June 23, 2023

**Re: Wycaro 339 – 9200 Scenic Dr. NW  
Erosion and Sediment Control Plan  
Engineer's Stamp Date 6/20/23 (H21E020)**

Based upon the information provided in your submittal received 6/20/23, the above referenced ESC Plan cannot be approved until the following comments have been addressed.

ESC-1

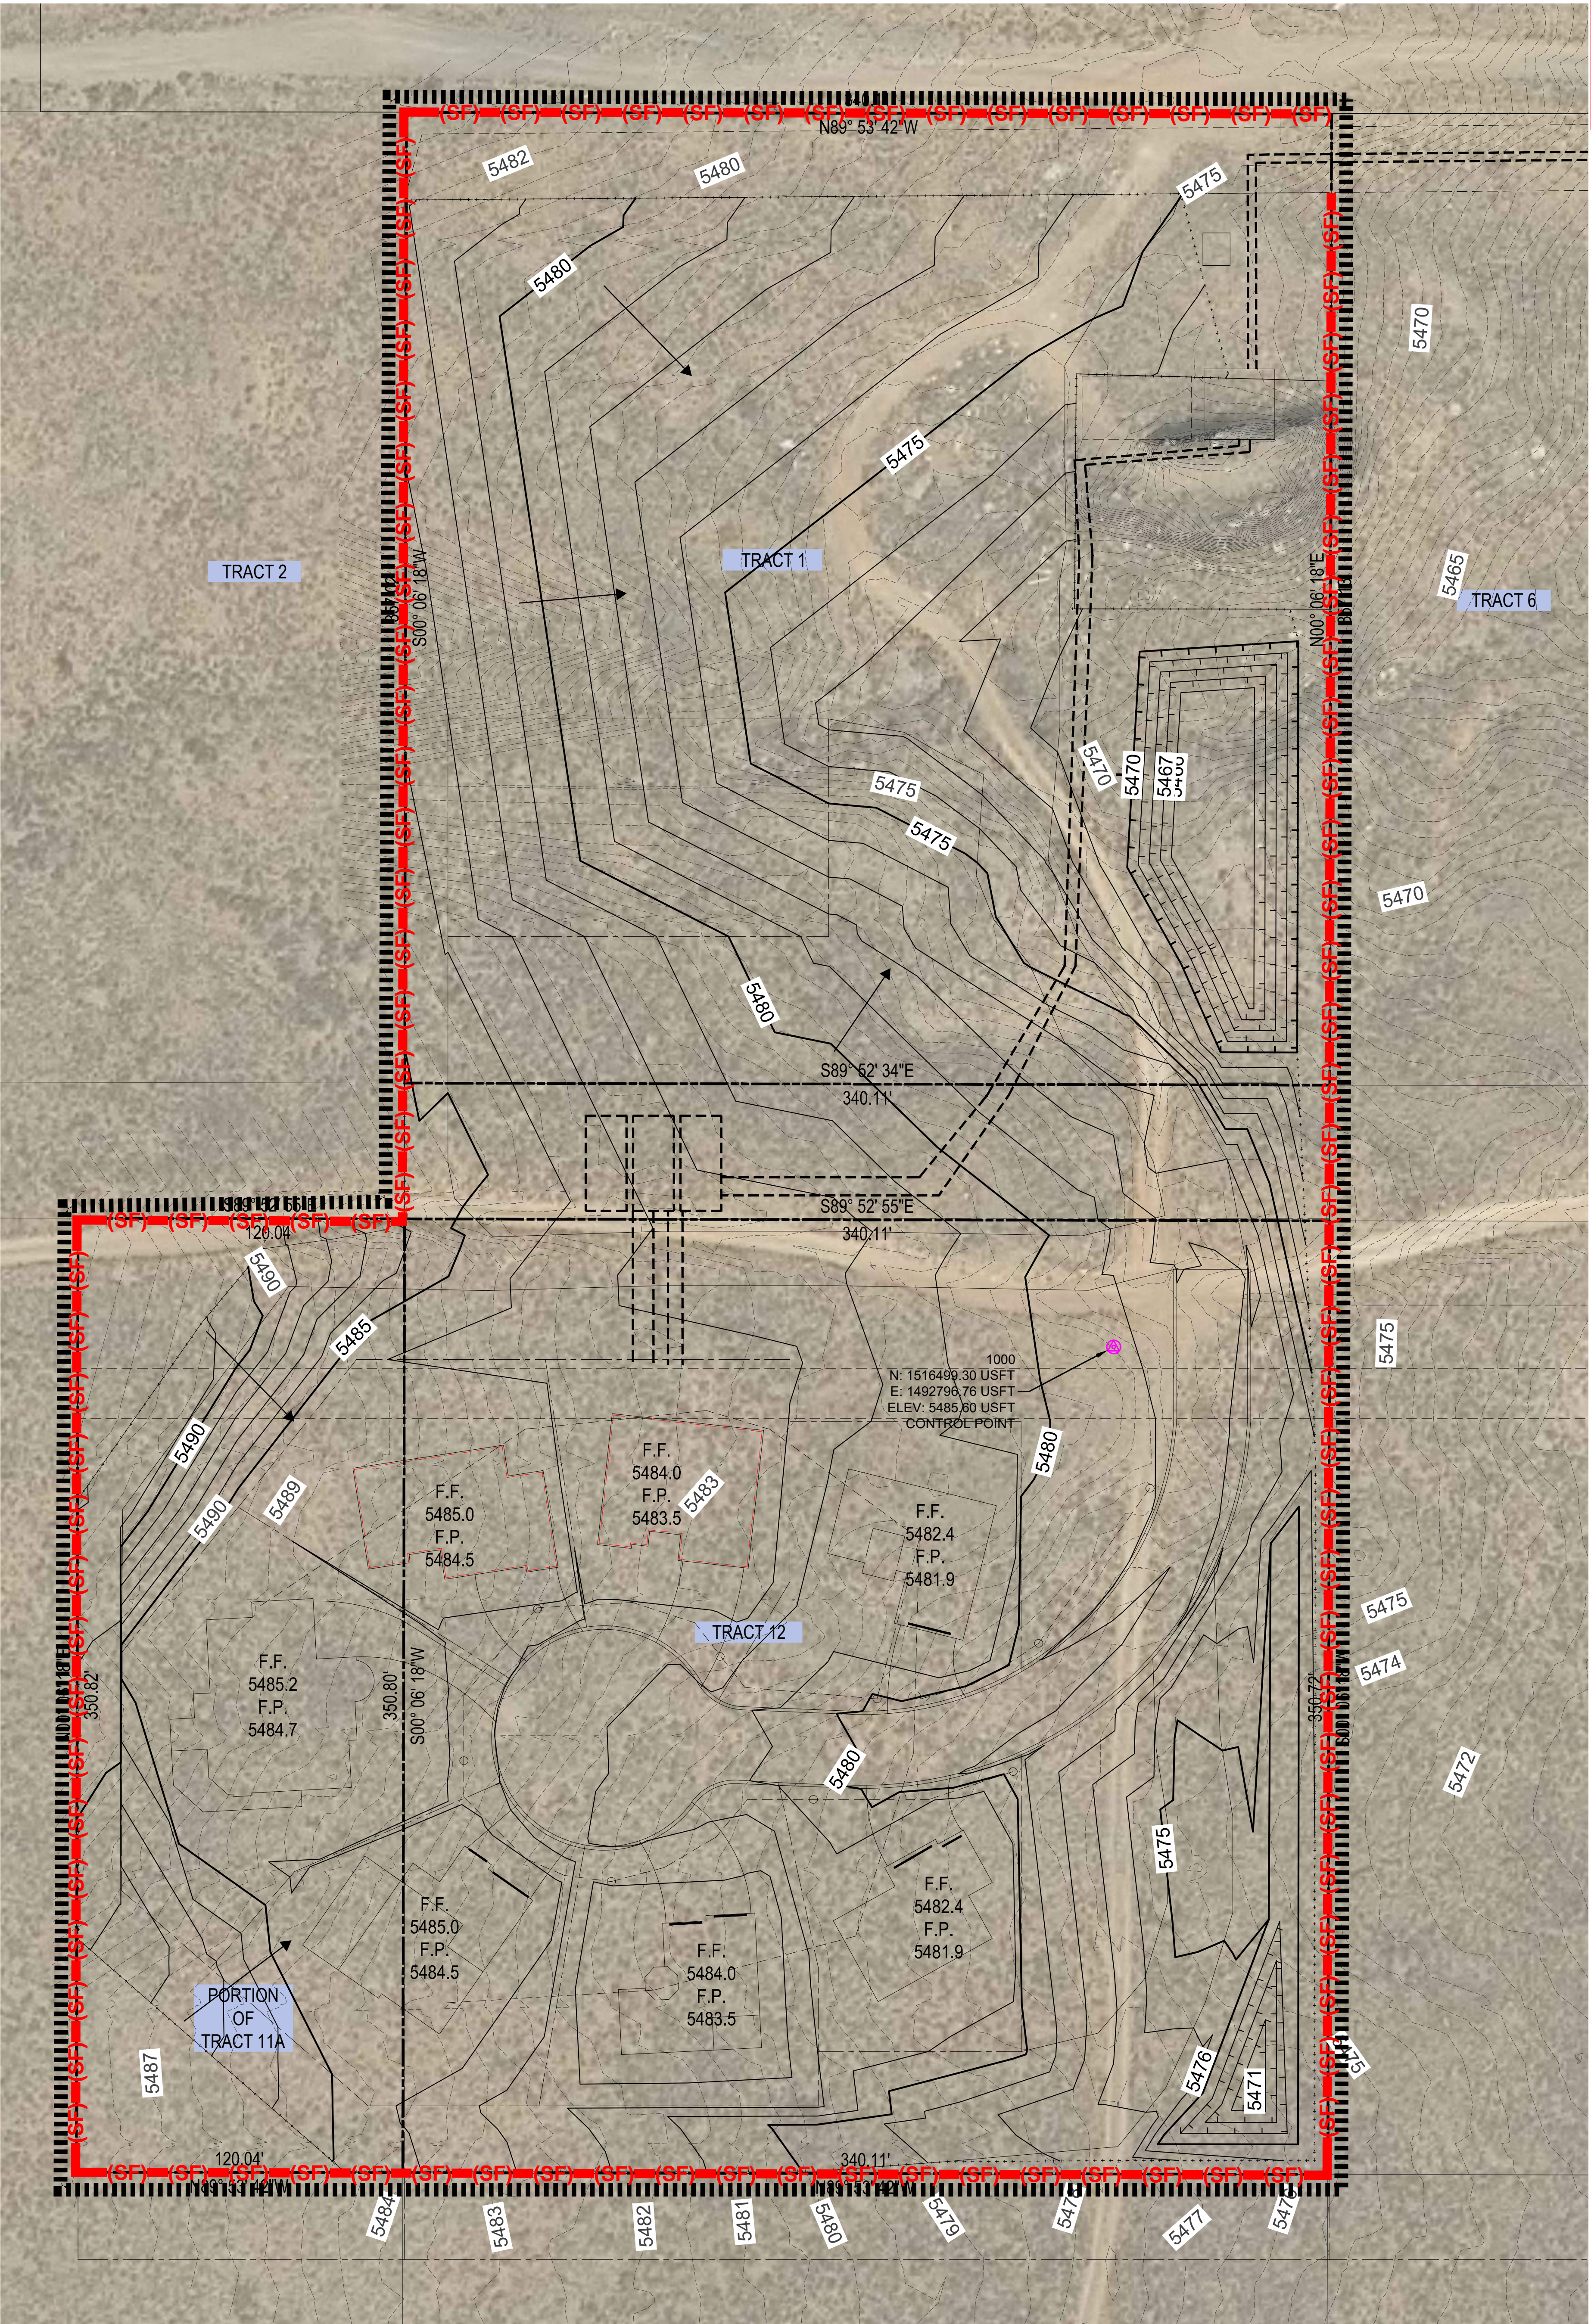
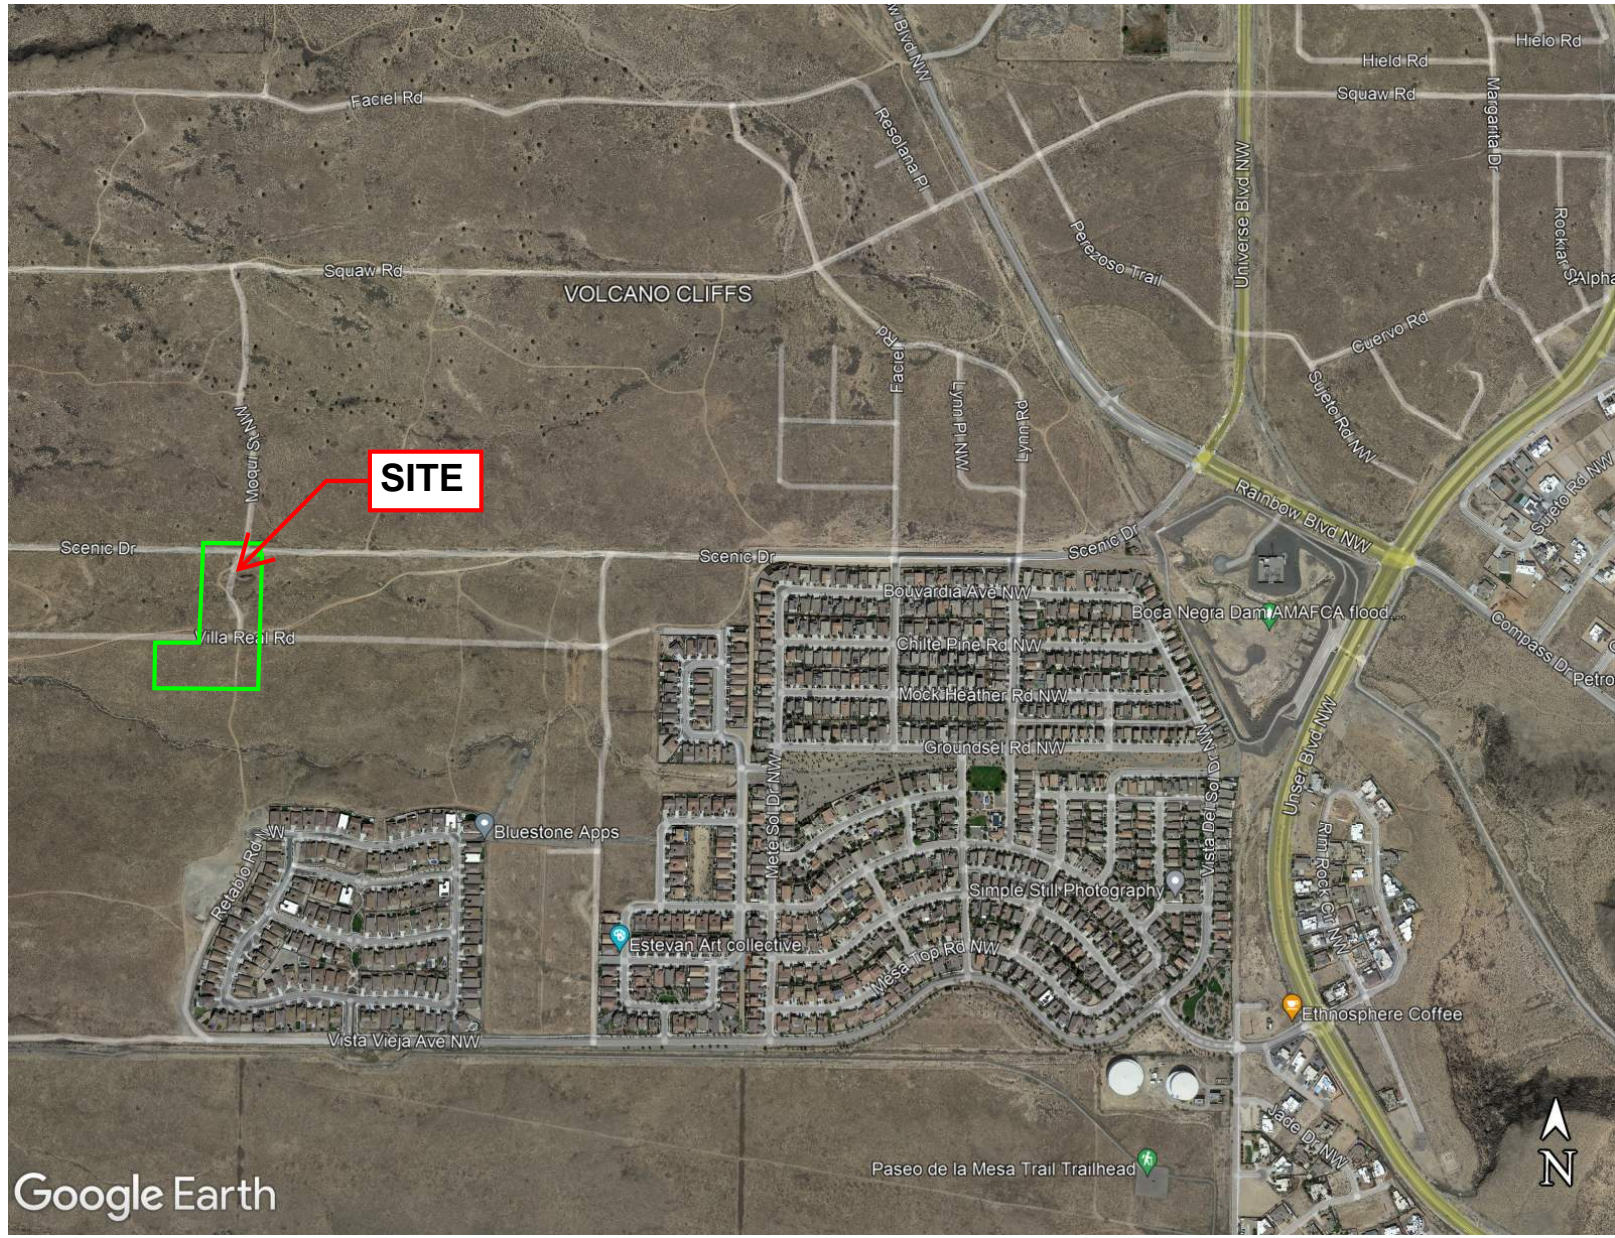
1. The ESC Plan can't be approved until after Hydrology approves the G&D Plan for each specific purpose; Plat, Grading, Building Permit, and Work Order. The existing and proposed grades must be shown on the ESC Plan, and they must agree with the Grading Plan approved by Hydrology (CGP7.2.4.b.ii). There may be more comments after the G&D Plan is approved.

3. Identify locations of concentrated flow paths that enter and exit the disturbed areas. Identify locations where sheet flow enters and exits the disturbed area. Show on-site drainage patterns of stormwater before and after major grading activities. (CGP 7.2.4.f)

4. The land disturbing activities associated with access and utilities to this site are missing from this plan and must be shown on the ESC Plan after the design is approved by Hydrology and Transportation.

5. The structures (buildings, streets and sidewalks) shown on this plan are vague and must be more clearly defined both onsite and offsite either on this ESC Plan or on a separate sheet like a Site Plan.
